RE: EIS Exhibition of SSD-10285 Royal Randwick Racecourse - Leger Lawn Development

Thank you for notifying Sydney Water of SSD-10285 on the Leger Lawn at the Royal Randwick Racecourse, which proposes a 5,043m² GFA 2-storey structure, to be known as the Winx Stand. Sydney Water has reviewed the application based on the information supplied and provides the following comments to assist in planning the servicing needs of the proposed development.

Kristine Leitch
Growth Intelligence Manager
City Growth and Development, Sydney Water
1 Smith Street, Parramatta NSW 2150

Figure 32 – Proposed Sydney Water sewer main diversion works

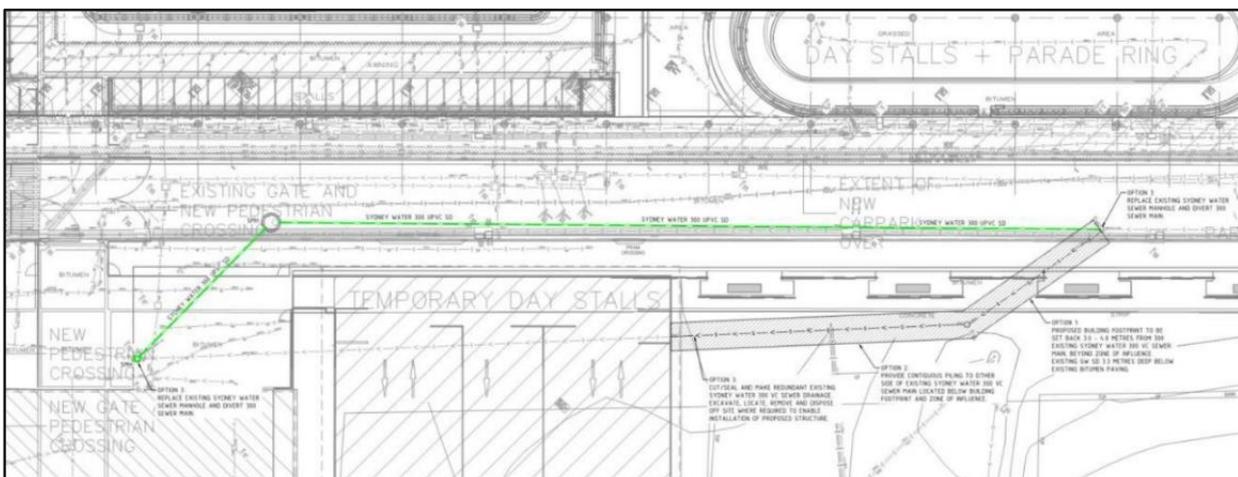
- Wastewater servicing should be available to serve the development. Amplifications, adjustments, and/or minor extensions may be necessary.
- As noted in the EIS the proposed stand is to be constructed over the existing DN225 sewer located within the site.
- The EIS suggests that deviating the main is the only option. No discussion of the future status of the deviated main was included. It may serve the needs of both Sydney Water and the Trust if the affected sections and any upstream sections of main came under the ownership of the Trust.
- The detail of the proposed changes to the DN225 sewer must be included in the Section 73 application.
